NSW RURAL FIRE SERVICE

Your Ref: SSD 9103
Our Ref: D18/627
DA18071814060 PC

New Macksville Hospital - Old Coast Road, Macksville (SSD 9103) - exhibition

Client:	Health Infrastructure	Job No.	RGS31237.1
	Project:	Proposed Macksville Hospital	Drawn By:	MR
			Date:	12-Apr-18
	Title:	Site Plan With Hospital Plan Layout	Drawing No.	Figure 3

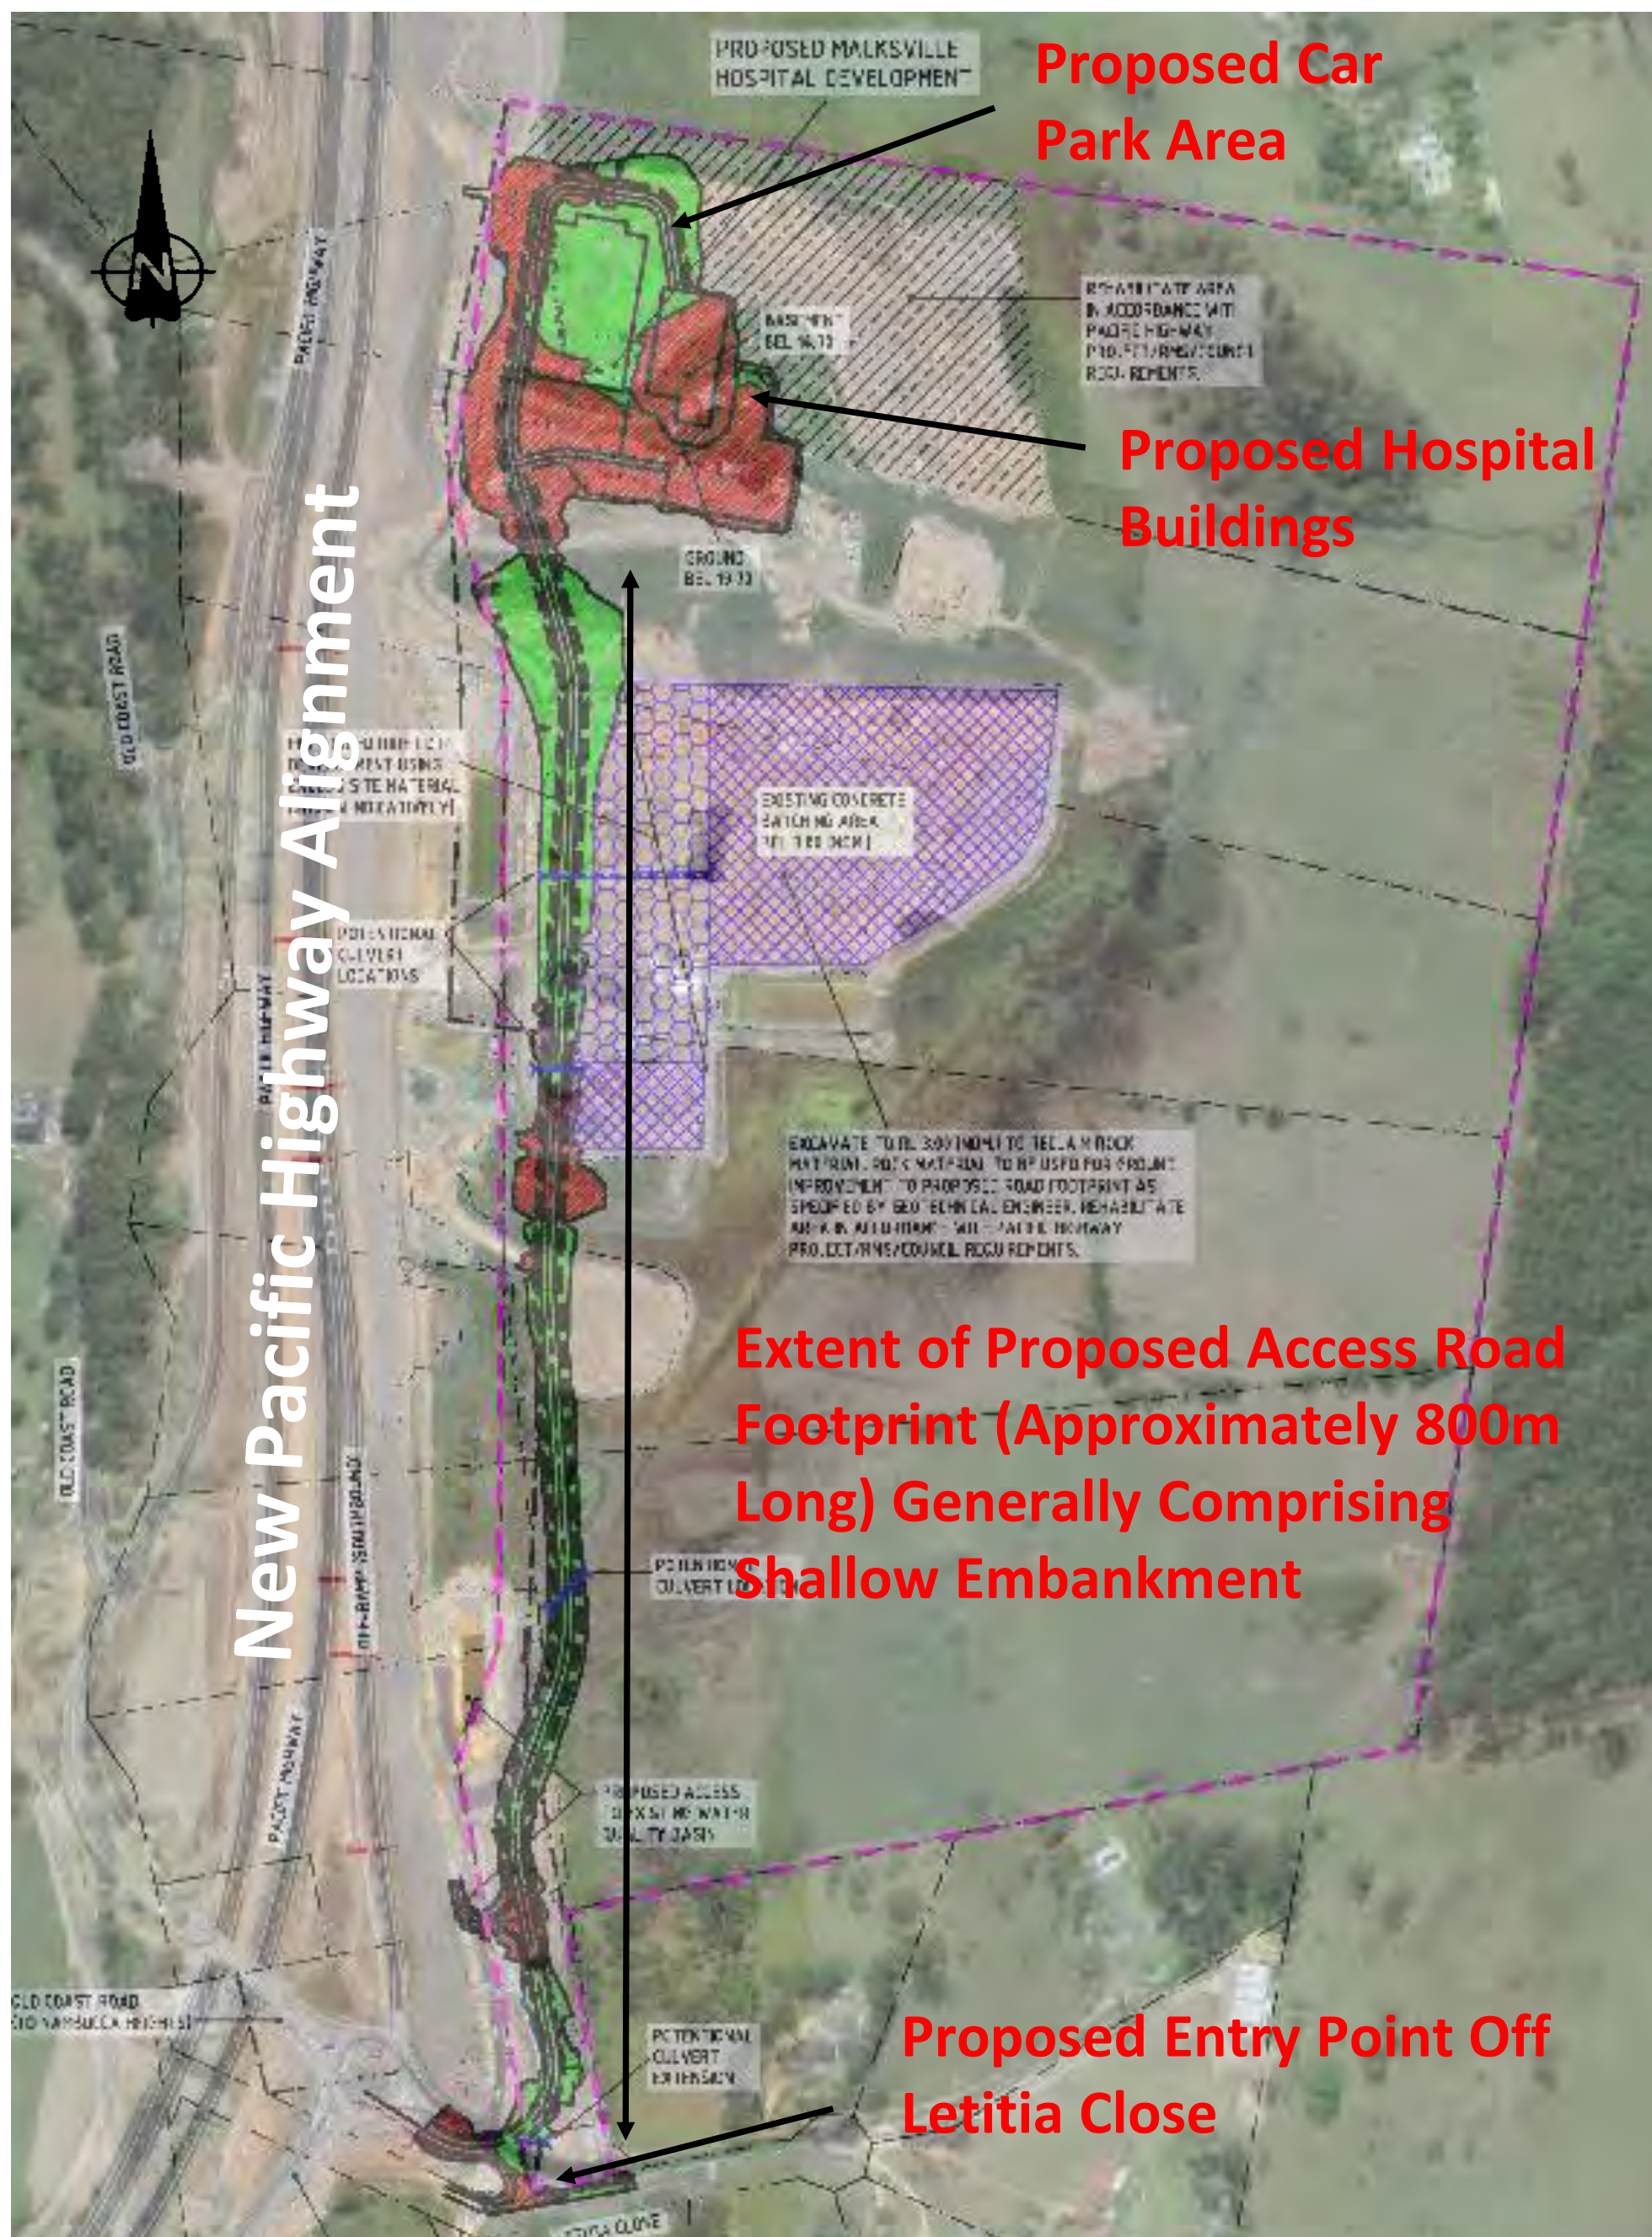
- the southern access road from Letitia Close is >100 metres in length from a public through road;
 - details of the 'fire service road' off the north-west corner of the car park are required; and
